(Engineering comments by Jeff Rice)

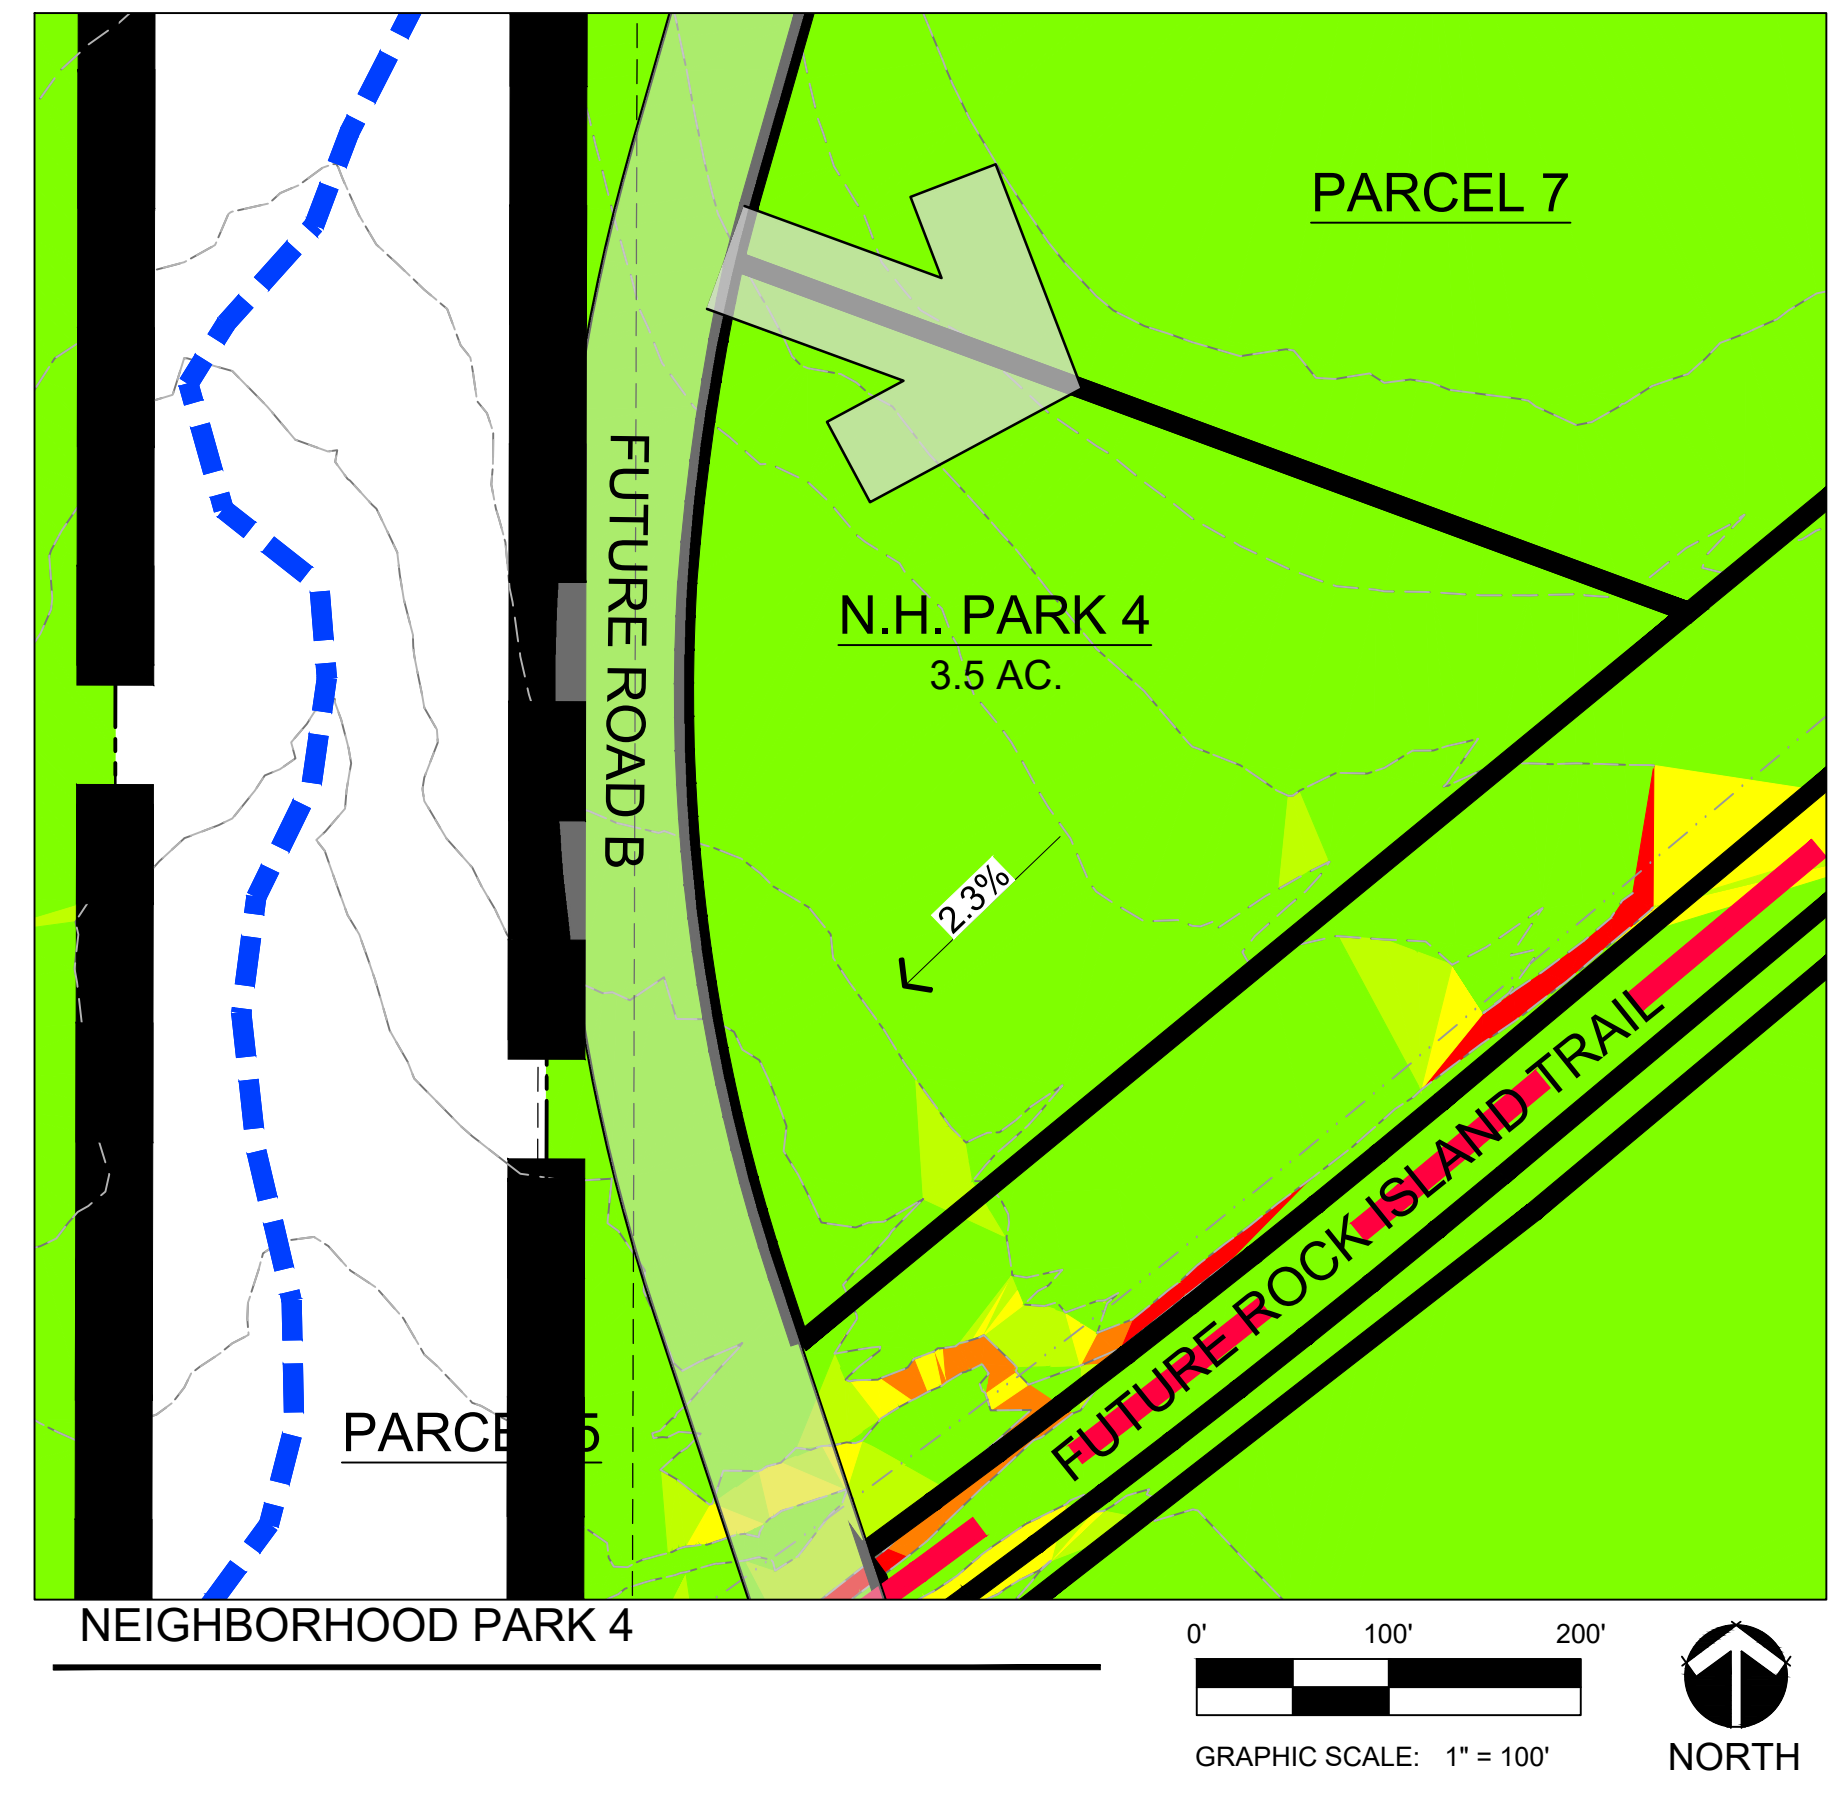
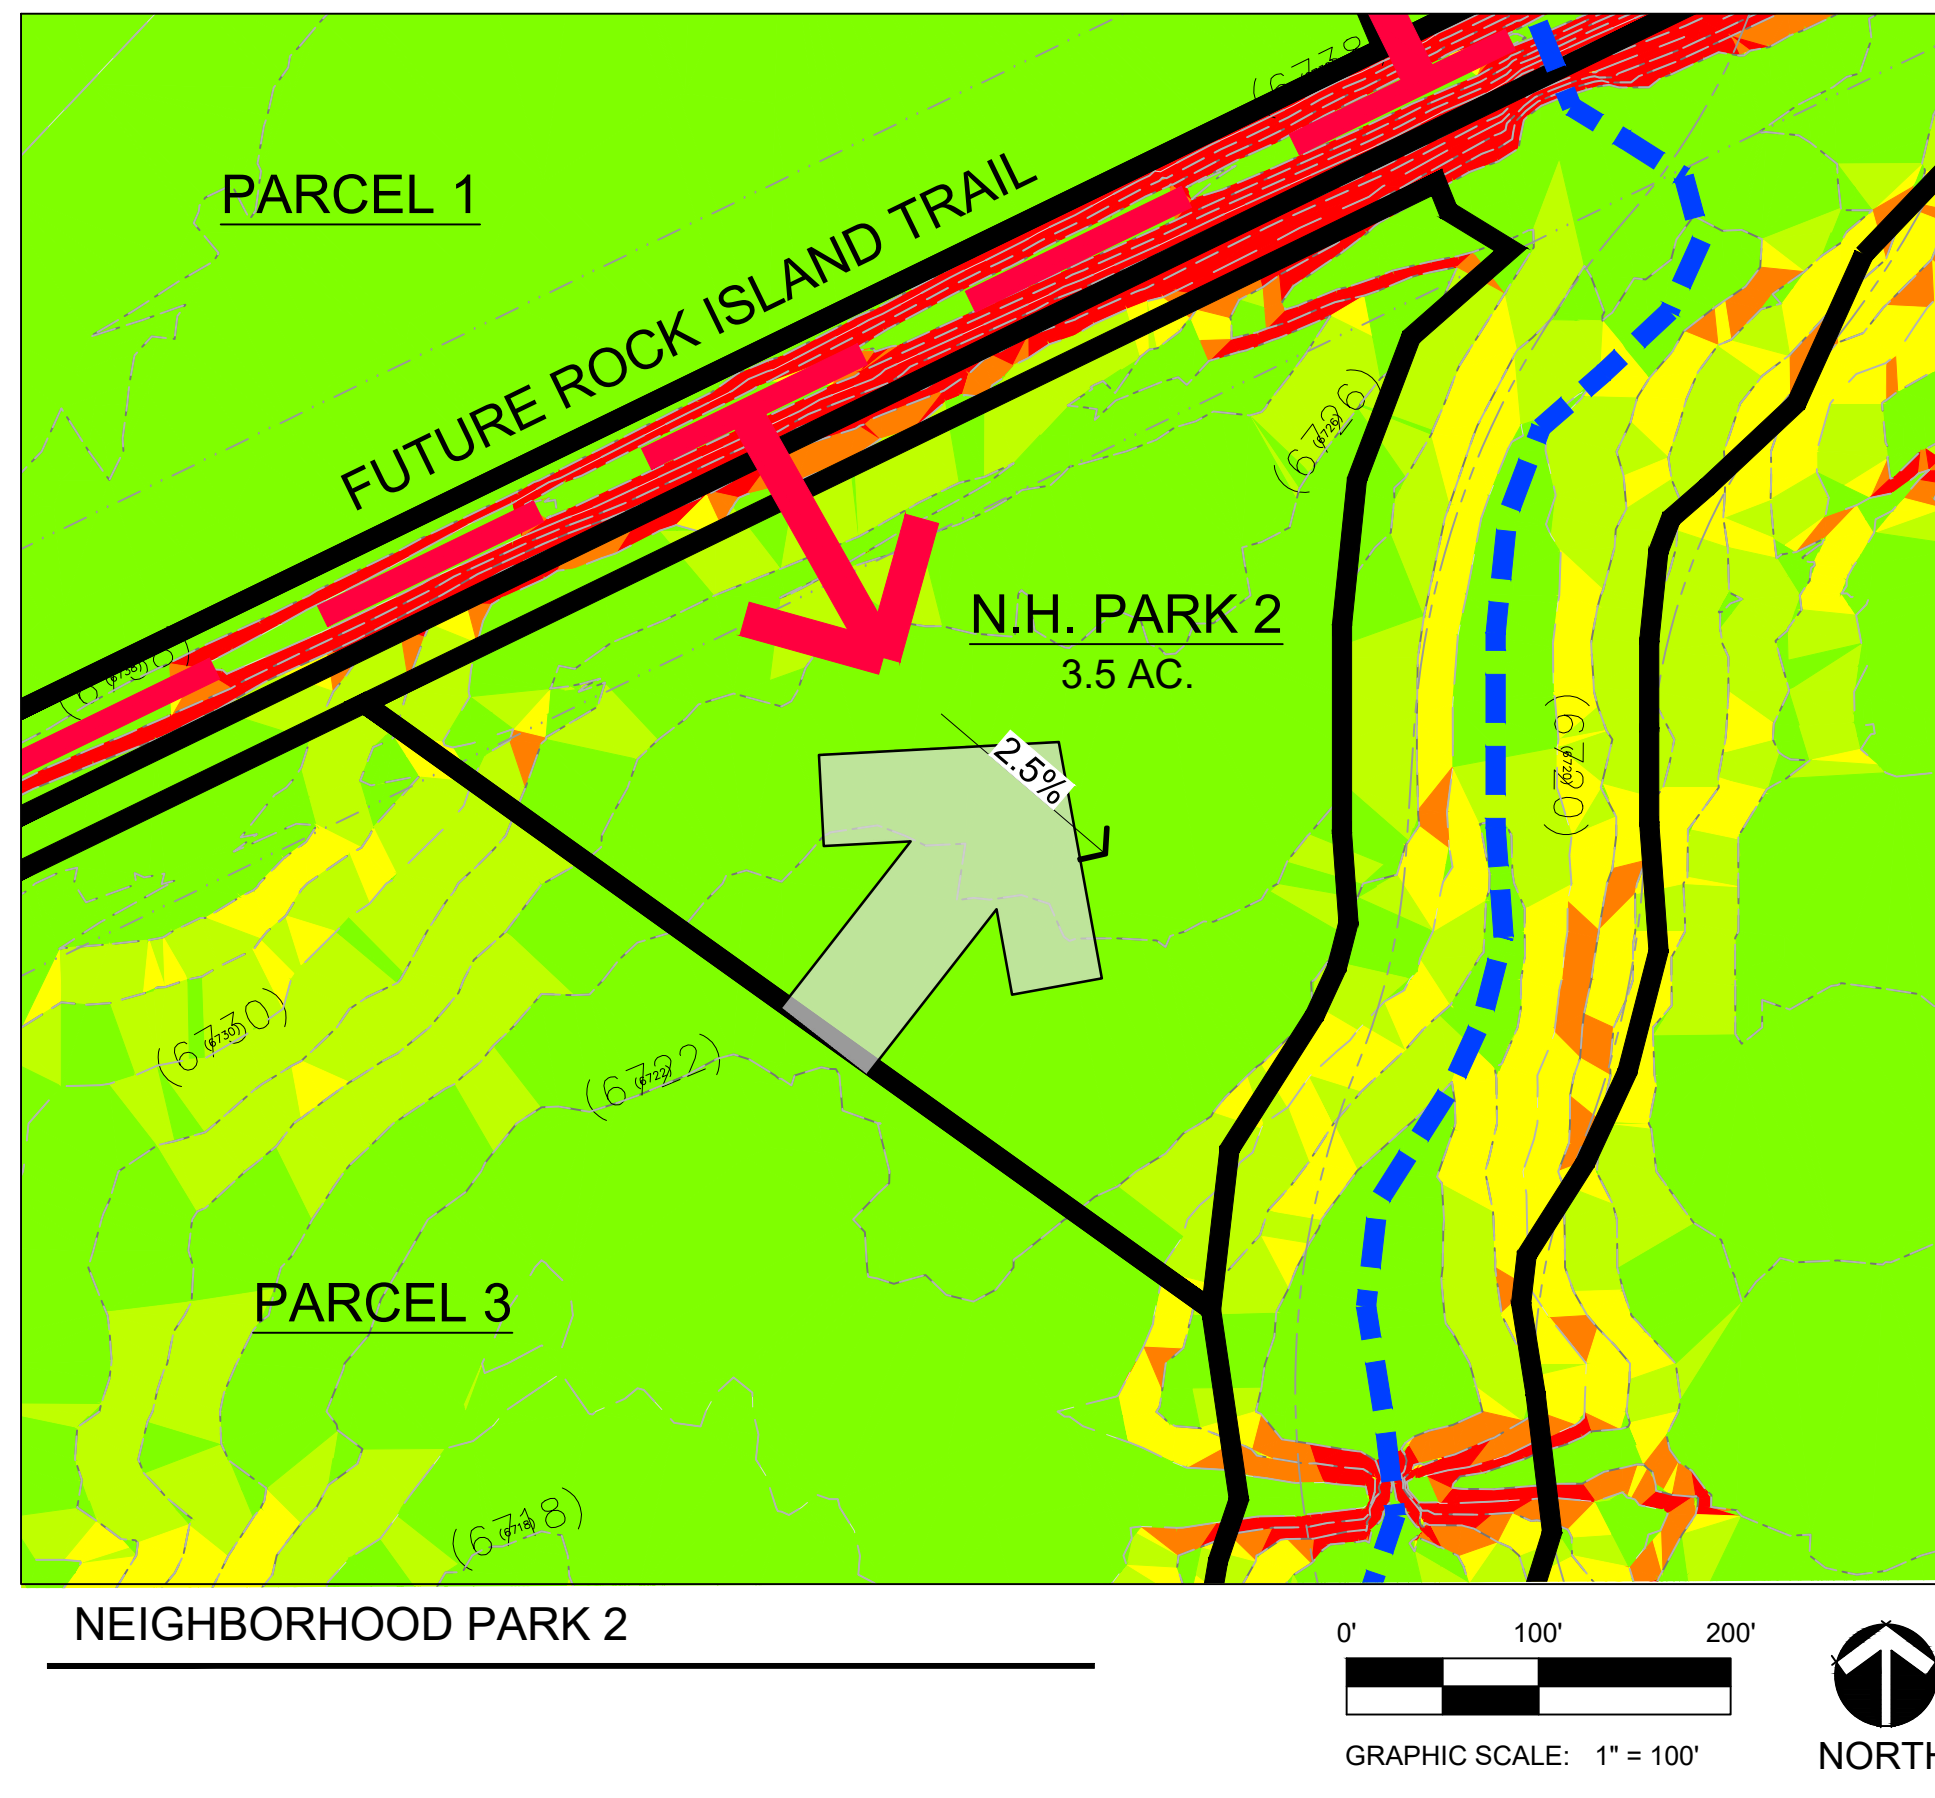
Why is ROW half of what is needed? (If Dublin is proposed to be split between incorporated and unincorporated areas, property acquisition from Falcon Highlands and EPC will be needed and County trail alignment (Rock Island and Falcon Hwy routes) in Tamlin Road ROW will need to be addressed.) (There was some coordination with Tim Roberts at the City in July 2022.)
